2024/0481

43 Park Avenue, Penistone, Barnsley, S36 6DL

Single storey rear orangery extension to two-storey semi-detached dwelling

Drawing
Proposed Ground Floor
Plan

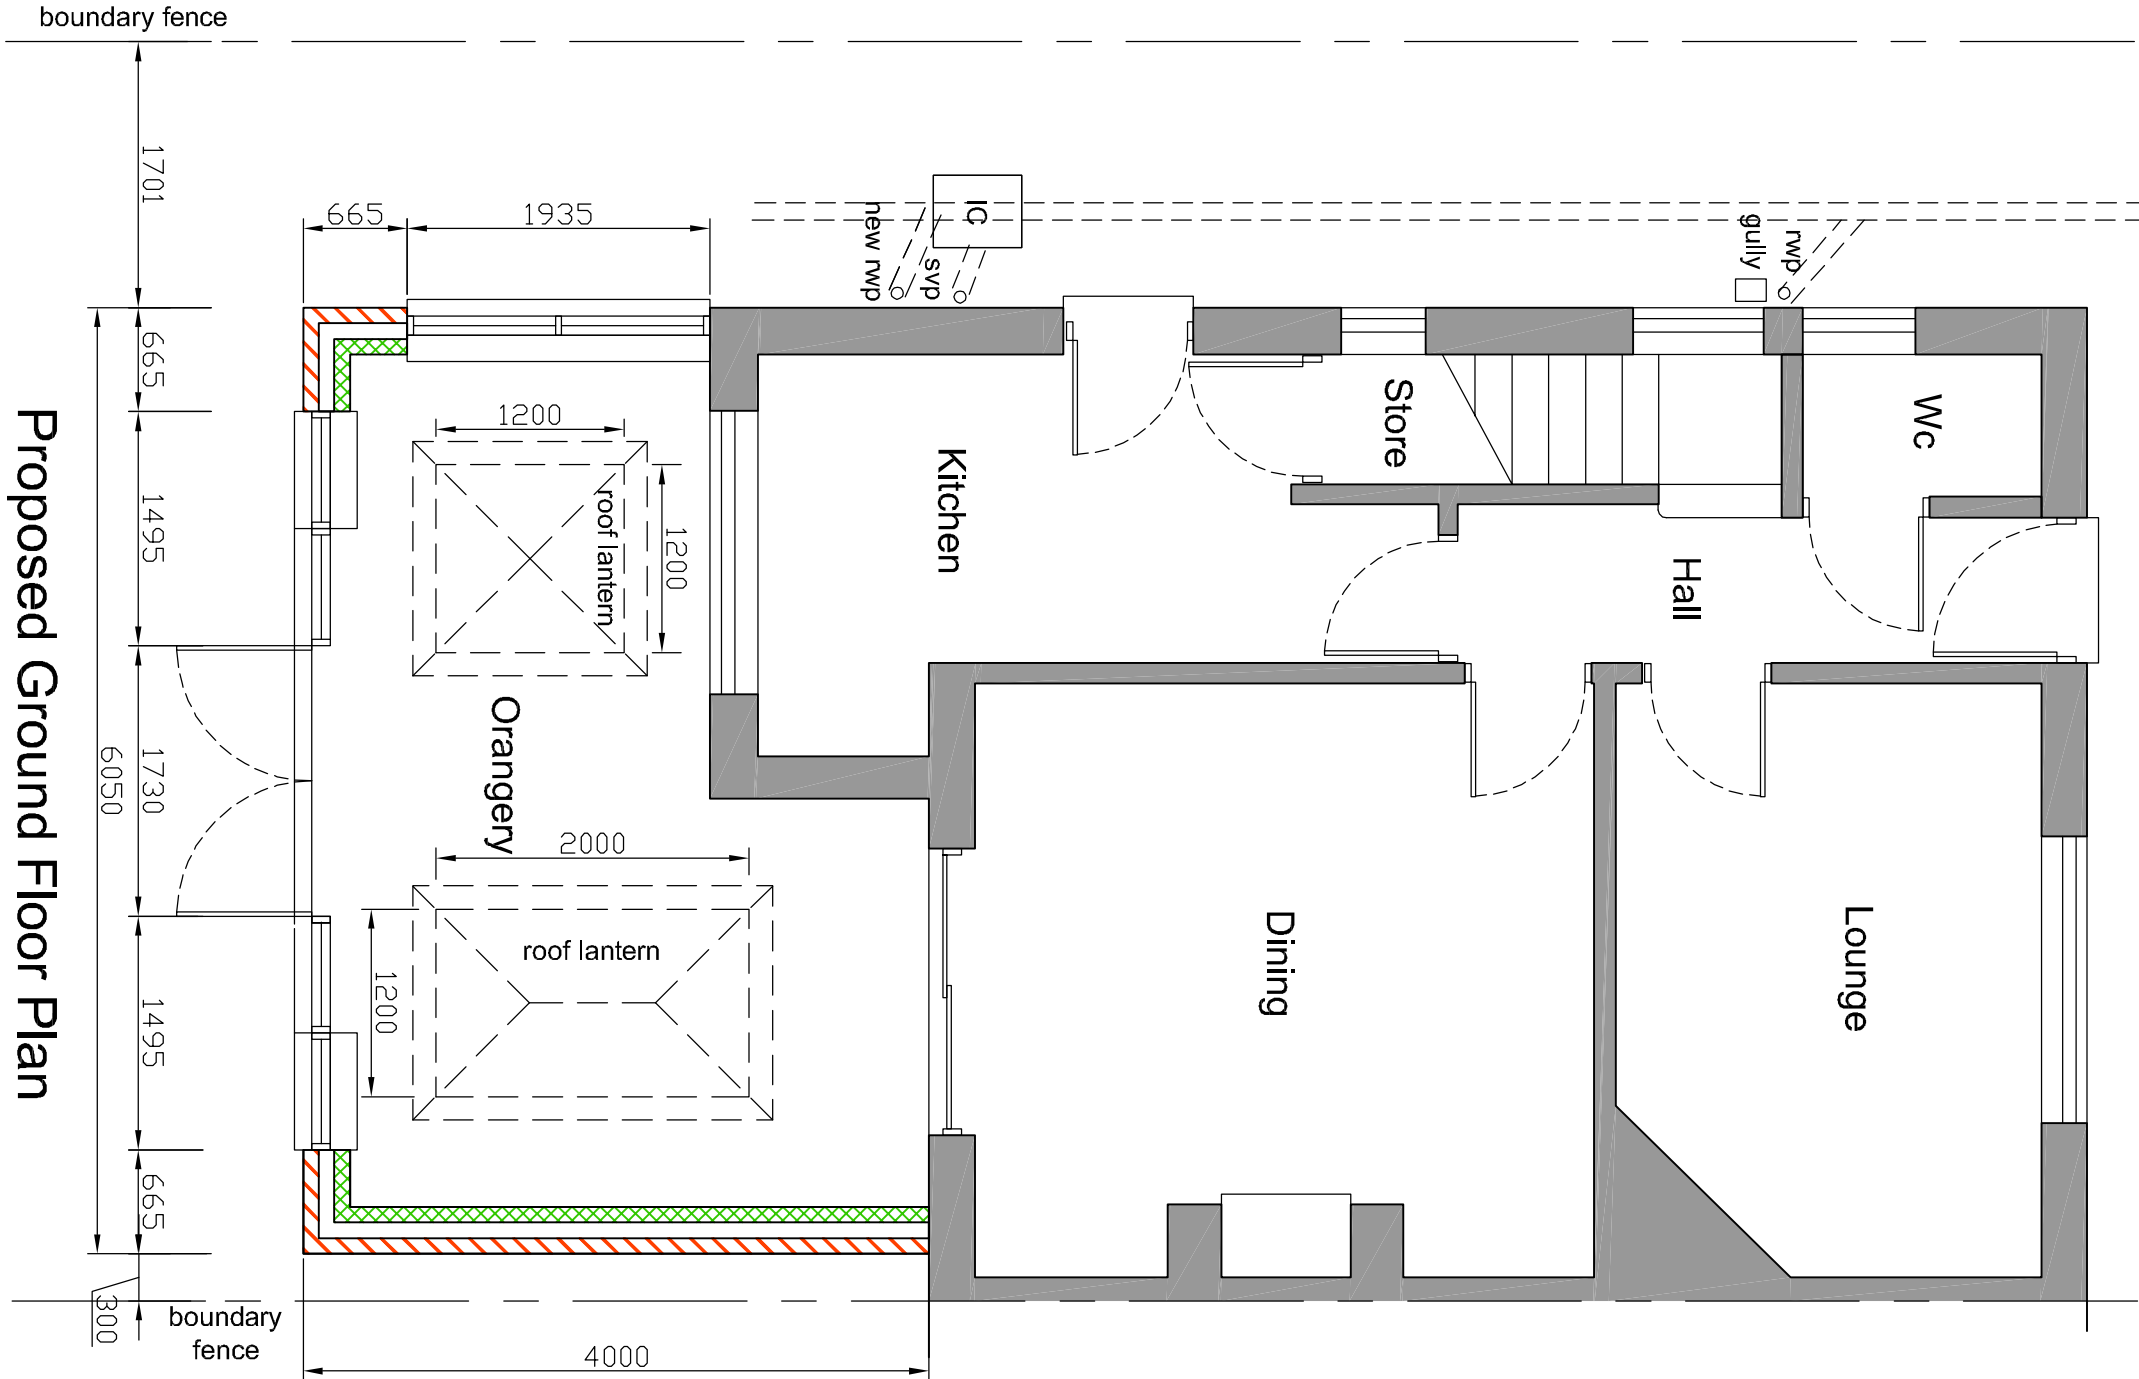
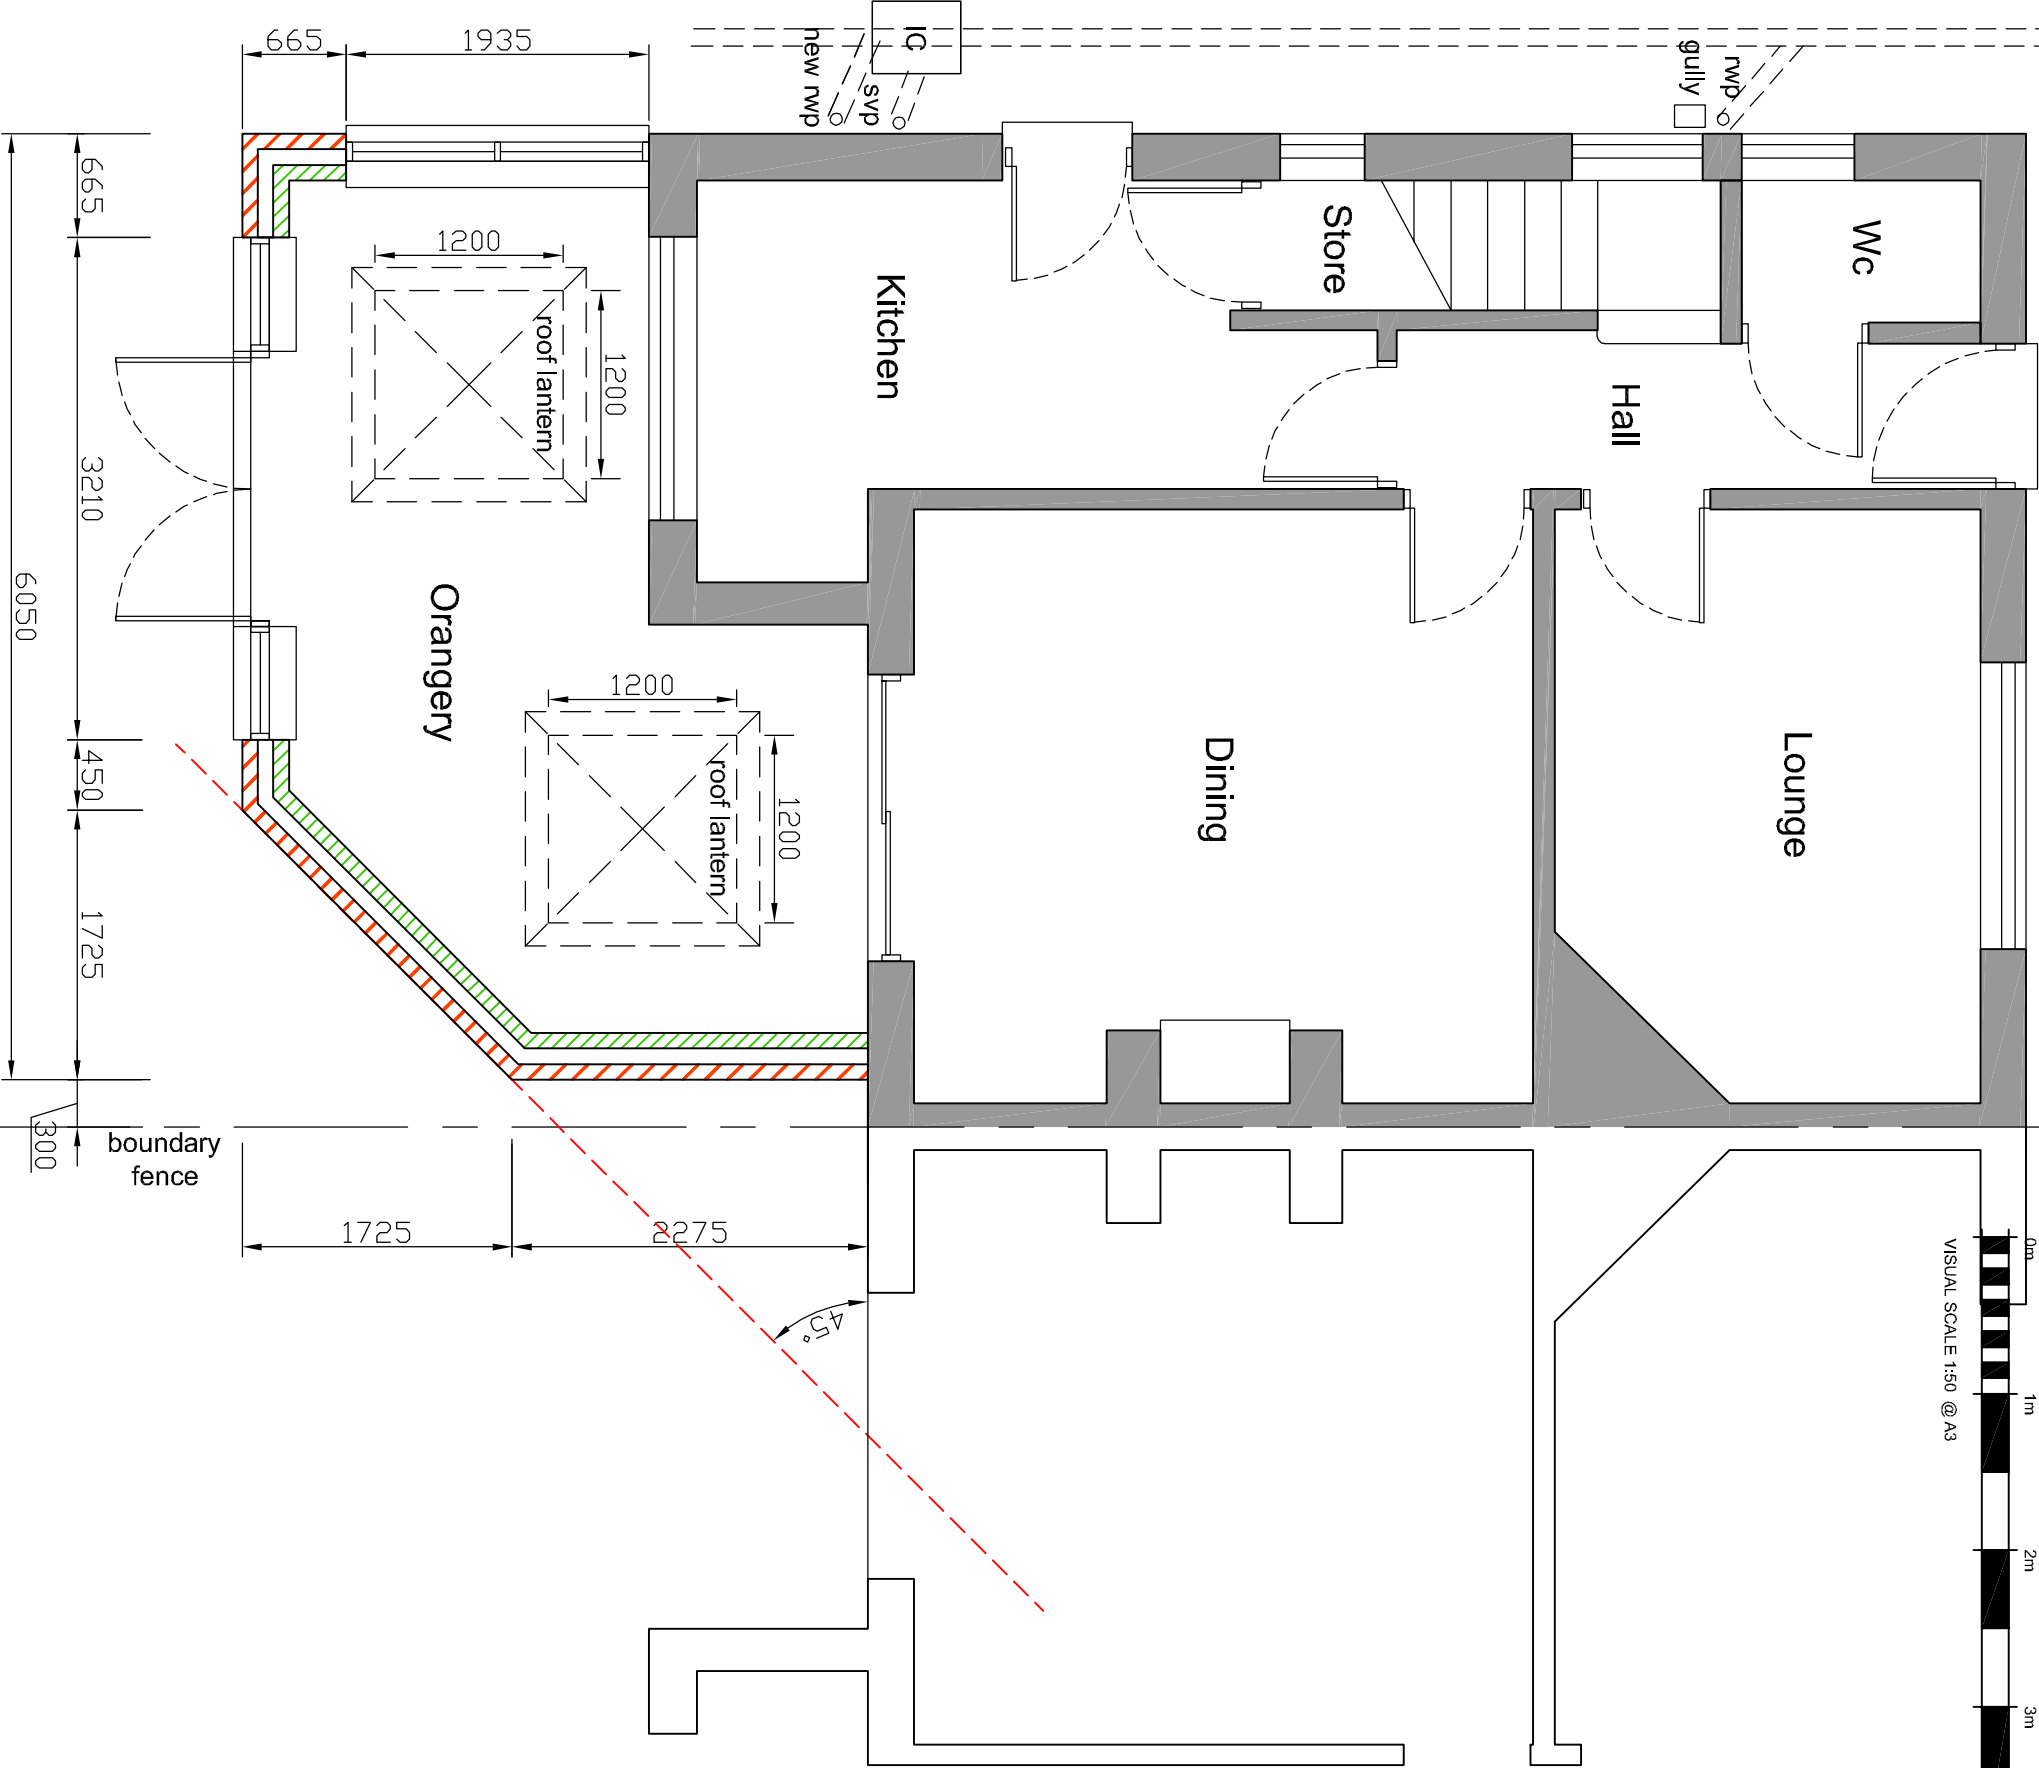
- The neighbour at No.41 Park Avenue will have the majority of light and view blocked at the rear of the property. Could the development adjacent to the boundary be taken further into the ground of No.43 to allow more light and view given the direction of the sun's movement means a significant loss of light to the rear of the property.

- This orangery will go 4 metres down the edge of my property. This will impact my property by blocking out my light and sun for almost the entire day, except an hour or two first thing in the morning. My garden and patio will become a sunless and dark area instead of the bright area it is now with the sun being in my garden most of the day.

- Concerned that the public sewer is not being shown on plans or considered by the applicant, who appear to be trying to dismiss its presence to construct a large orangery extension.

- The direction of the sewer on the plans is the wrong direction as far as I am concerned to aid their application. I assume that Yorkshire Water (YW) will need to be consulted as far as I am aware as they will need to be cross the sewer and almost run in close along the alignment.

- The public sewer runs parallel to the rear of the property (roughly 3.5m based on recent tracing by YW at my property). I guess that as this is classed a temporary structure it can be built over the public sewer, however, considerations will need to be made for the influence on the pipe and foundations will need to be deepened accordingly.

The SPD states that *“on semi-detached dwellings an extension should not project more than 4 metres and again, the eaves height should not exceed 2.5 metres where the extension would project beyond 3 metres”*. The proposed rear extension conforms to the above guidance. The proposed extension will not have a significant detrimental impact on any neighbouring property by way of overshadowing or being overbearing due to its limited projection which is only 1 metre greater than what could be achieved using permitted development rights. Additionally, adjacent the adjoining dwelling (41 Park Avenue) an extension could be erected greater than the proposed projection along that boundary as it is only 2.3 metres in projection, therefore 0.7 metres short of the 3 metres allowed using permitted development rights which would not require planning permission.

With regards loss of outlook and sun light, the SPD states *“the 45° test shall be applied to the nearest window of any adjacent residential accommodation which lights a habitable room or kitchen and to comply with the rule any extensions should be designed so as not to cross a 45° line, when drawn from the midpoint of the nearest window opening of the adjacent dwelling”*. The 45° test has been applied and the proposal amended to comply to this by reducing the projection adjacent the adjoining dwelling therefore allowing for more light to reach the habitable room window on the rear elevation of the adjoining dwelling and subsequently the area in front of it. In terms of overlooking no windows are proposed on the side elevation facing the adjoining dwelling and the windows on the rear elevation are set to the side away from the adjoining dwelling due to the design of the extension. The proposal is considered to be in compliance with Local Plan Policy GD1: General Development and is acceptable in terms of residential amenity.

The applicant is seeking approval for the erection of a single storey rear extension. The extension will project 4 metres from the rear elevation of the dwelling and has since been amended to reduce the projection to 2.3 metres adjacent the adjoining dwelling. The extension has a width of 6.05 metres. The extension will feature a flat roof with a total height of 3.3 metres and an eaves height of 2.4 metres. The materials used will be matching brickwork.

With regards the drainage and sewer issues related to the proposed extension these would be dealt with separately under building regulations approval and do not form part of the basis for decision making on this application. The direction of the sewer is of no consequence to the planning assessment of the proposals on the plans. Additionally, Yorkshire Water have not been consulted as this is a householder planning application and therefore it is not a requirement to consult them. Furthermore, because this is a householder planning application a construction method statement is not required.
